From: Grant, David
Sent: 24 January 2022 09:04
To: _planningadvice
Subject: FW: 55 Station Road H17-1199-21

Please add this email to the DIP under 6SUP – Door details.

Plan No. 101A

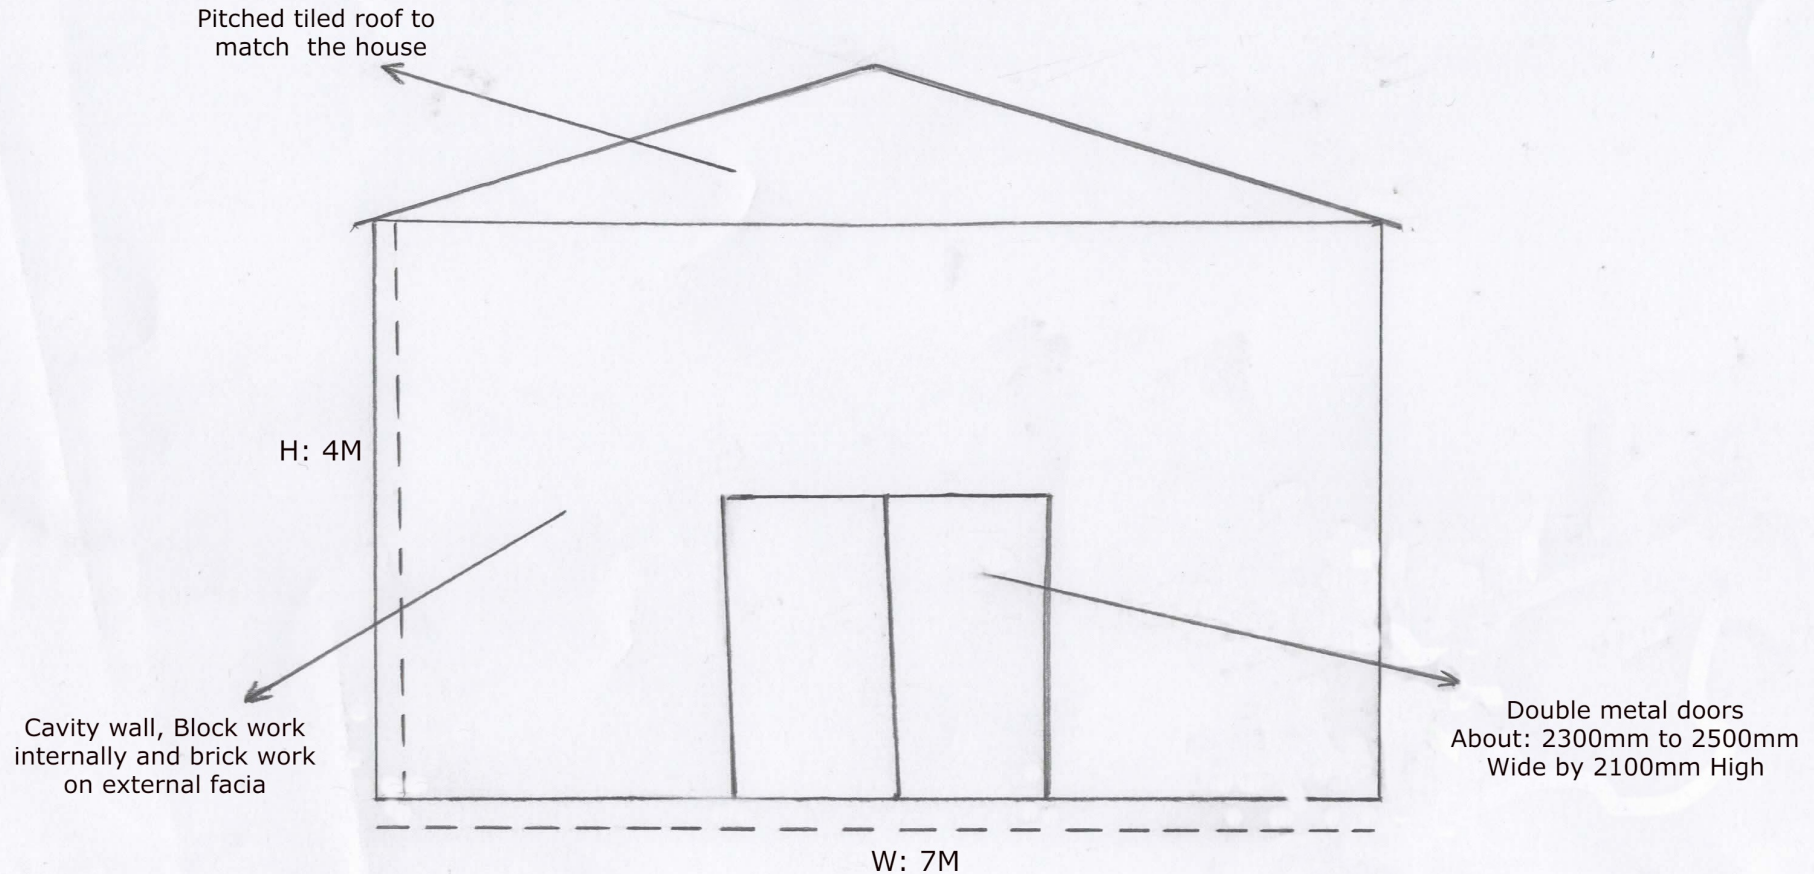
So that the application can have a decision issued on or before Tuesday, can you please confirm whether the front elevation door is to be a roller shutter door or double barn doors? Please all confirm the materials of construction for your chosen option.

Dear Mr Grant, thank you for your kind email, the front doors will be double barn doors and not a roller shutter, thank you.
